Submission ID: SBC59959F

## Flooding Concerns – Site G (Greenhill Solar)

# **Engineering Report: Assessment of Surface Water Runoff from Proposed Green Hill Solar Farm (Green Hill G)**

**Subject: Preliminary Opinion of Surface Water Runoff and Contribution to Localised Flooding from the Proposed Green Hill Solar Farm (Green Hill G)**

Title:
Figure 8.1.5 Site Locations and Study Area
Green Hill G

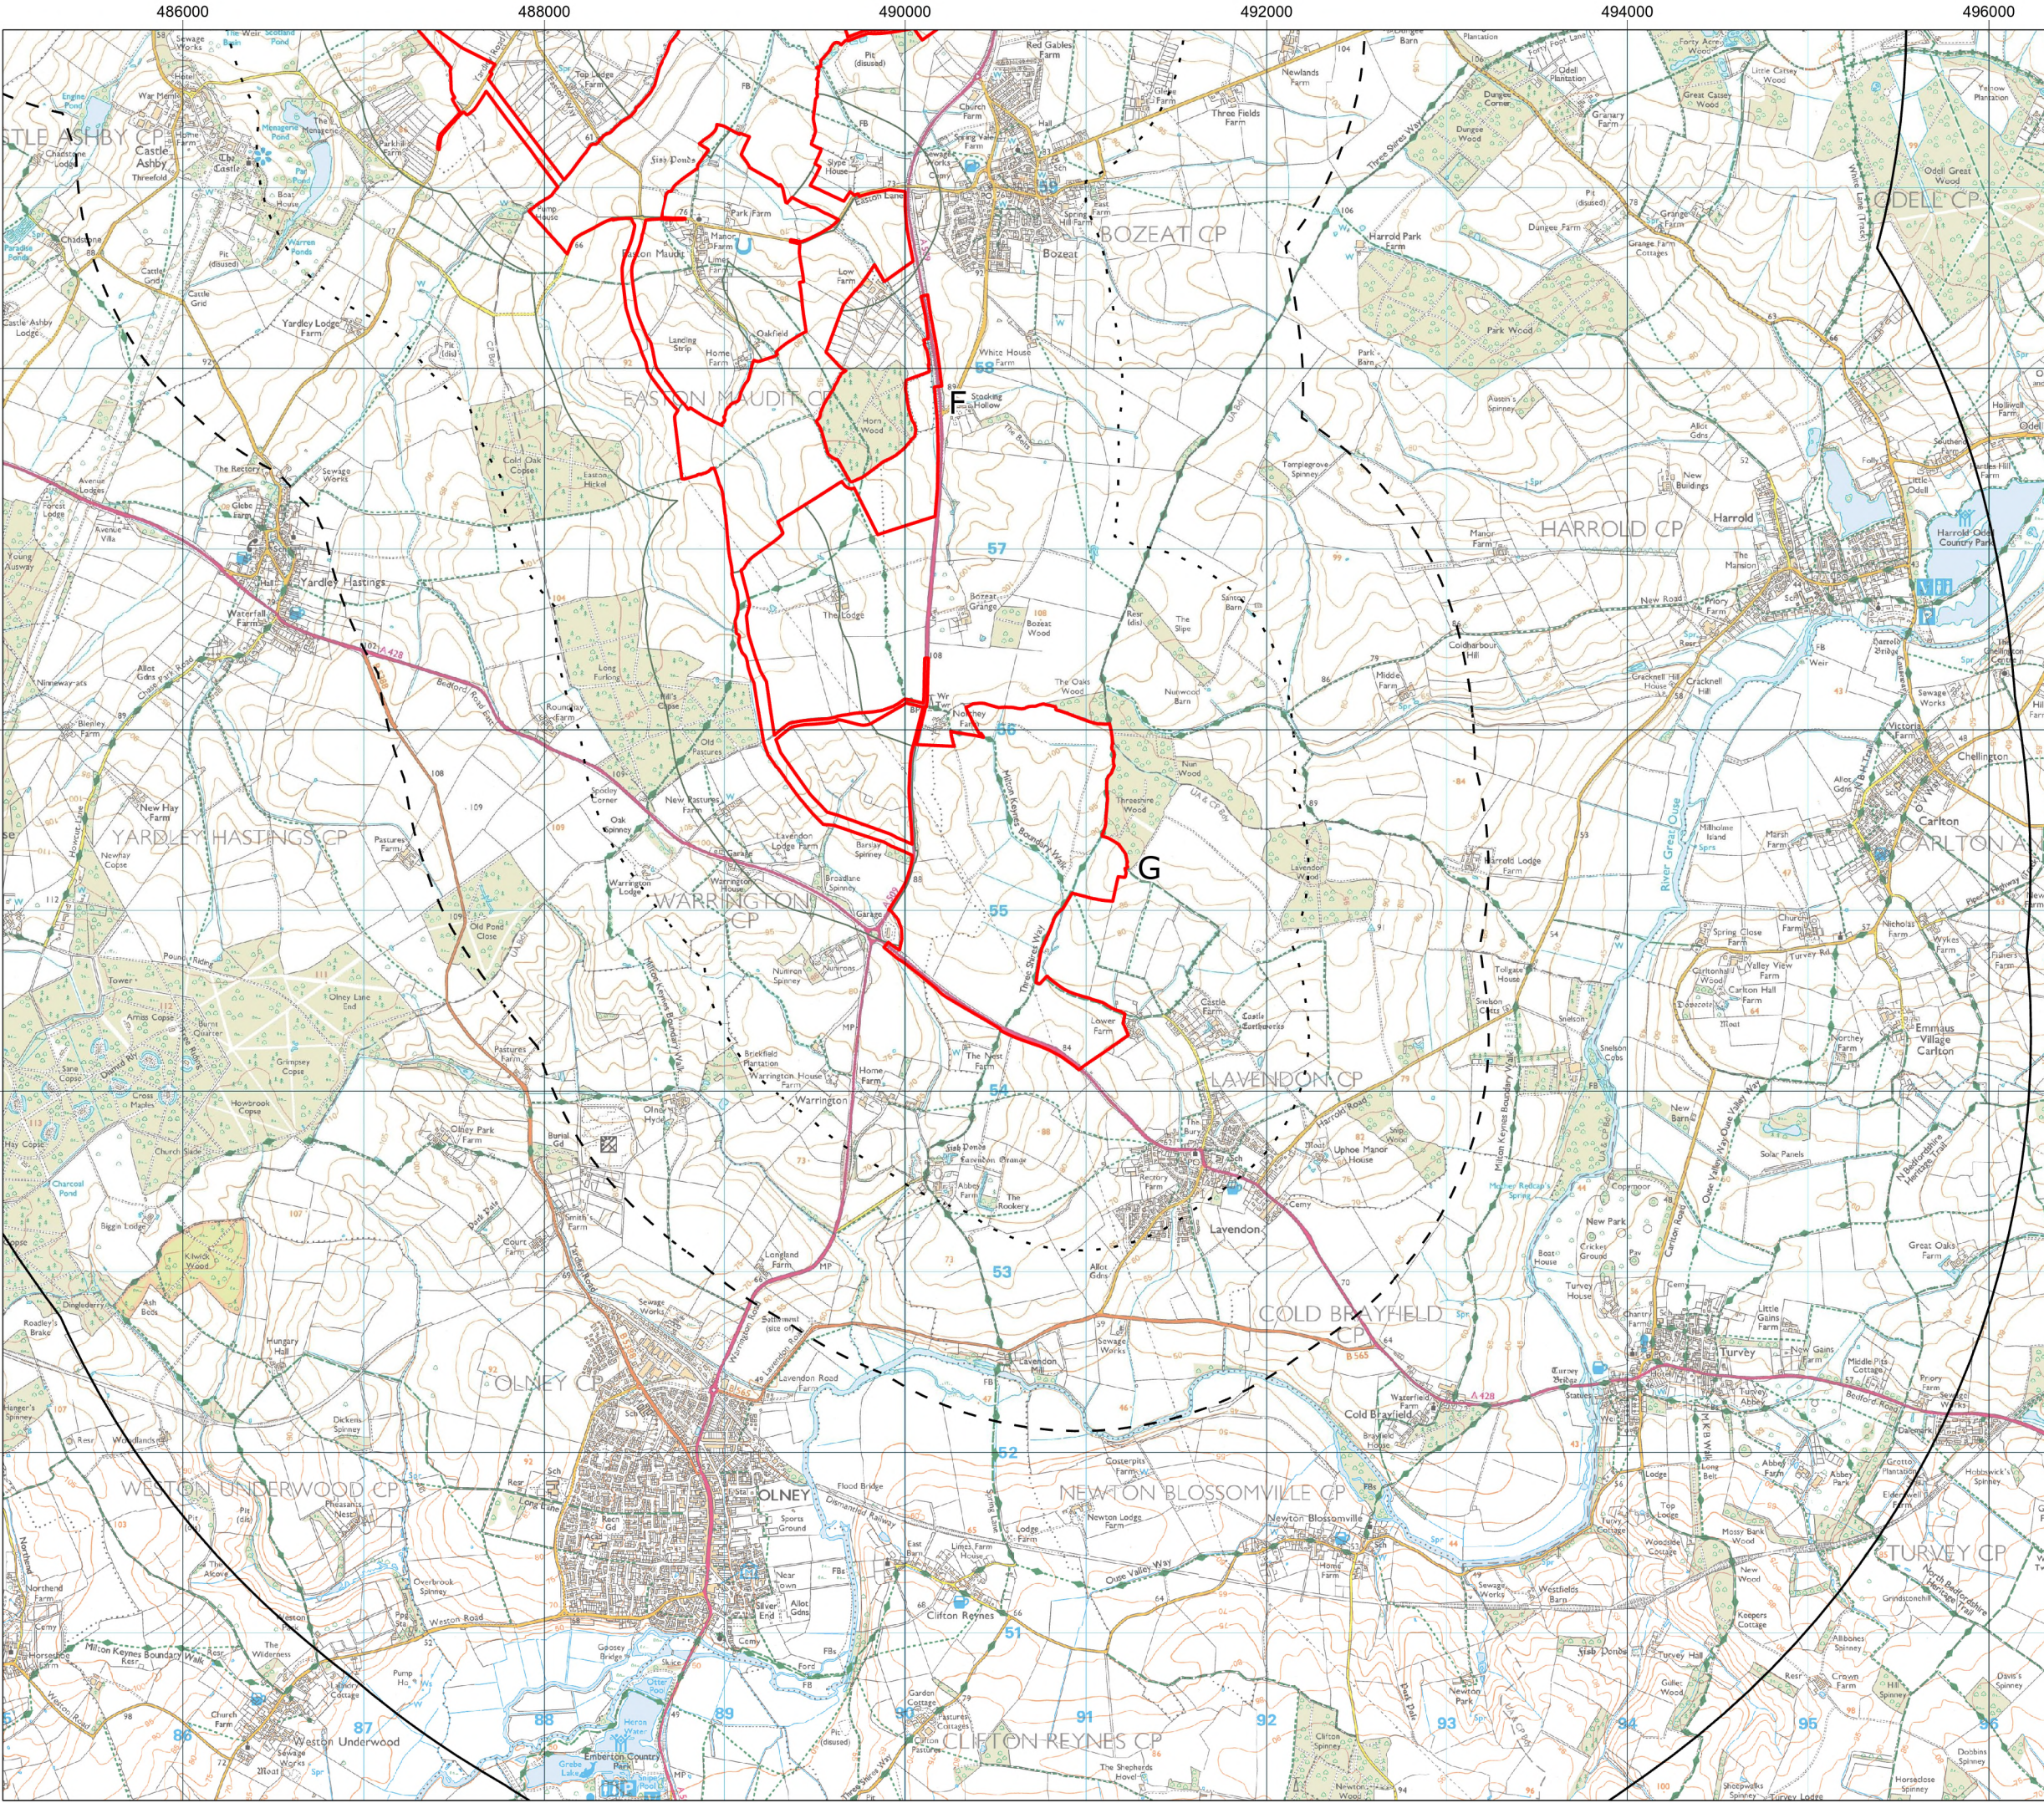
We **disagree** with this conclusion. Area G has **complex, largely non-permeable ground conditions** that lead to significant surface water run-off during intense rainfall events, posing a genuine flood risk.

Our property, **Lower Farm**, lies at the **southernmost point** of the Greenhill Solar Site G map, within a shallow valley at the end of **Castle Road, Lavendon**. The farm comprises **24 acres of pasture**, directly adjacent to **Site G13**.

The entire length of this drainage route—including its banks through Area G, Lower Farm, and Lavendon Village—falls within **Flood Zone 3a**.

| Cross Reference Clause | Statement                                                                                                                                                                                                                                                                           | Comment                                                                                                                                                                                                                                                                                                                                                                                                                                                                                                                           |
|------------------------|-------------------------------------------------------------------------------------------------------------------------------------------------------------------------------------------------------------------------------------------------------------------------------------|-----------------------------------------------------------------------------------------------------------------------------------------------------------------------------------------------------------------------------------------------------------------------------------------------------------------------------------------------------------------------------------------------------------------------------------------------------------------------------------------------------------------------------------|
|                        | <u>Construction/Decommissioning Phase Compaction of Soils</u><br>Topsoil should be cultivated in-line with BS 3882: 2015 to a minimum depth of 400mm over all planting areas or to a fine tilth over all areas to be seeded and include basic levelling with levels graded to fall. | Green Hill G-13 only has 100mm to 150mm existing topsoil layer. Is this going to be built up?<br>                                                                                                                                                                                                                                                                                                                                             |

| Cross Reference Clause | Statement                                                                                                                                                                                                                                                                                                                                                                                                                                                                                                                                   | Comment                                                                                                                                                                                                                                                                                                                                                                                                                                                                                                                                           |
|------------------------|---------------------------------------------------------------------------------------------------------------------------------------------------------------------------------------------------------------------------------------------------------------------------------------------------------------------------------------------------------------------------------------------------------------------------------------------------------------------------------------------------------------------------------------------|---------------------------------------------------------------------------------------------------------------------------------------------------------------------------------------------------------------------------------------------------------------------------------------------------------------------------------------------------------------------------------------------------------------------------------------------------------------------------------------------------------------------------------------------------|
| 10.6.85                | Green Hill G is therefore considered to be at low risk of fluvial flooding.                                                                                                                                                                                                                                                                                                                                                                                                                                                                 | Green Hill G13 cannot be considered as being at low risk of fluvial flooding.                                                                                                                                                                                                                                                                                                                                                                                                                                                                     |

| Cross Reference Clause | Statement                                                                                                                                                                                                                                                                                                                                                                                                          | Comment                                                                                                                                                                                                                                                                                                                                                      |
|------------------------|--------------------------------------------------------------------------------------------------------------------------------------------------------------------------------------------------------------------------------------------------------------------------------------------------------------------------------------------------------------------------------------------------------------------|--------------------------------------------------------------------------------------------------------------------------------------------------------------------------------------------------------------------------------------------------------------------------------------------------------------------------------------------------------------|
| 2.2.38<br>Table 1      |                                                                                                                                                                                                                                                                                                                                                                                                                    | An Exception Test would be required for those portions of Green Hill G i.e. G-13.                                                                                                                                                                                                                                                                            |

I would therefore object to the continuance of Green Hill G as an option for inclusion in the proposed development, and in particular site G-13.
